**Consultation Response from KC,
Highways Development Management**

2025/90922 Newgate Garage, Newgate, Mirfield, WF14 8DB

Erection of outbuilding, extension of existing garage and associated alterations

Date Responded: 24-9-2025.

PROPOSED BLOCK PLAN
1:500

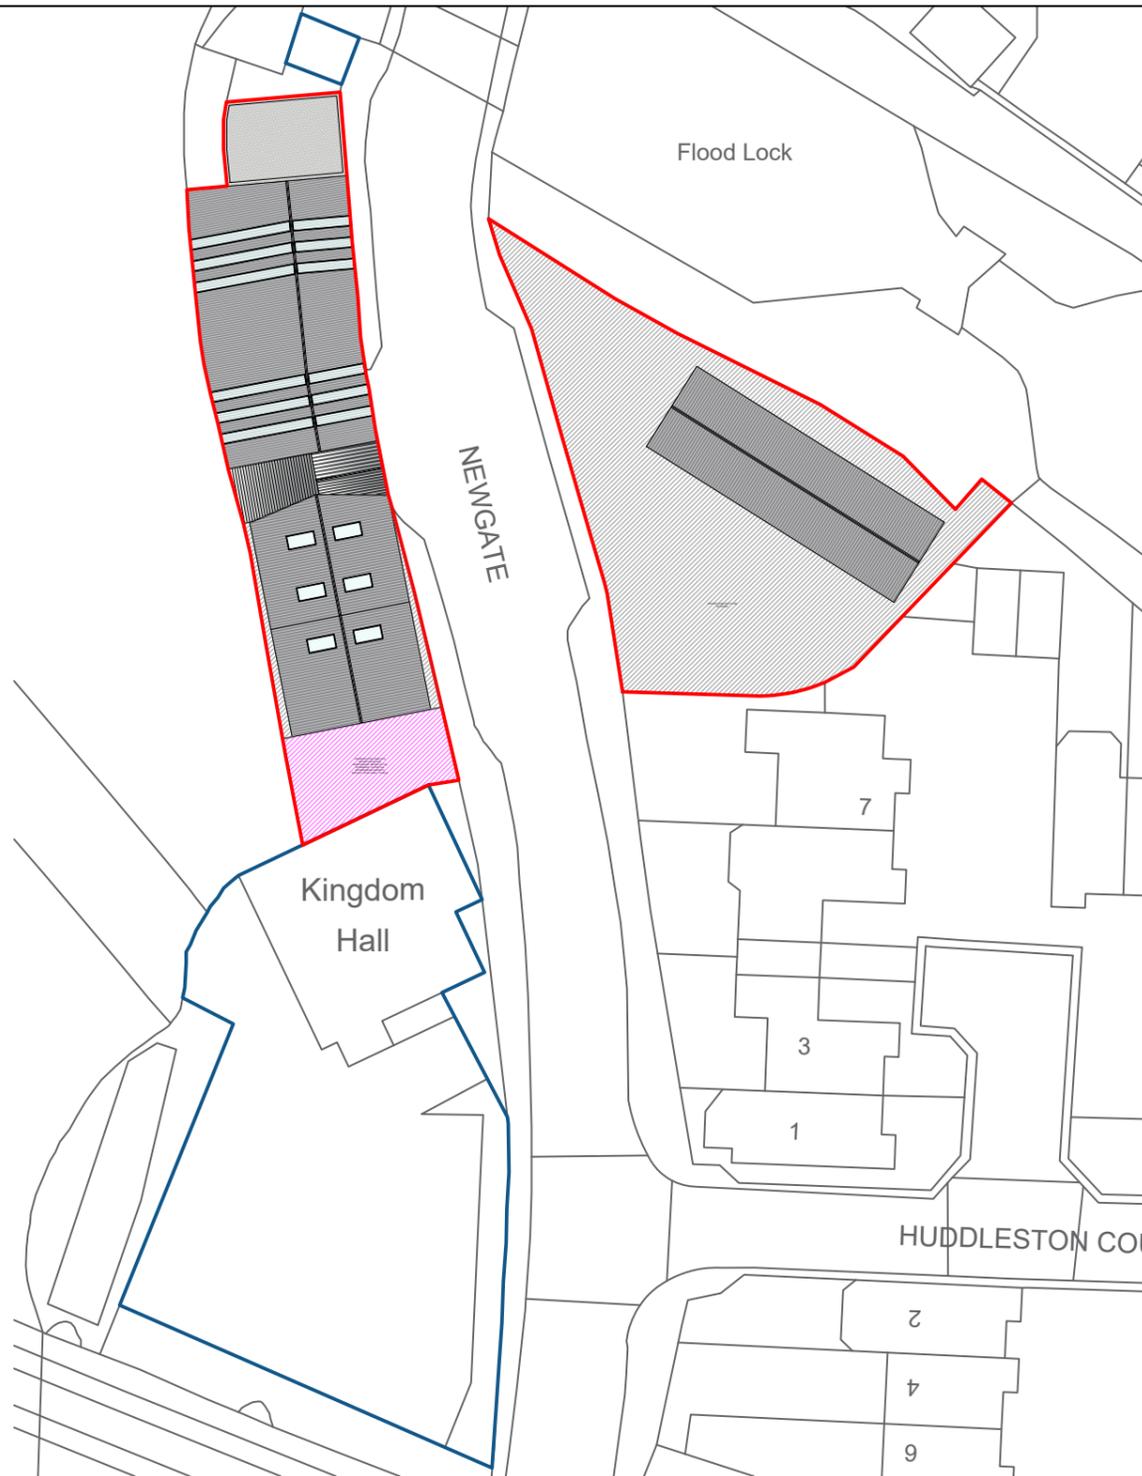
- 1, The extension and the proposed new building result in a loss of off-street parking provisions for the garage.
- 2, The proposals show 3 new service bays with direct access onto Newgate with no provision for internal vehicle turning.
- 3, Sight lines onto Newgate from all 3 service bays would be sub-standard in both directions.
- 4, Inter-visibility between vehicles exiting the service bays and pedestrian using the Newgate footway would also be poor.

Given the Highway Safety Section comments and the record of complaints regarding on-street parking along Newgate, and that these proposal will result in a loss of off-street parking facilities, access to the service bays is directly onto Newgate with no internal vehicle turning and with poor sight lines and poor pedestrian inter-visibility Highways Development Management have little option other than to recommend refusal of these proposals on highway safety grounds.
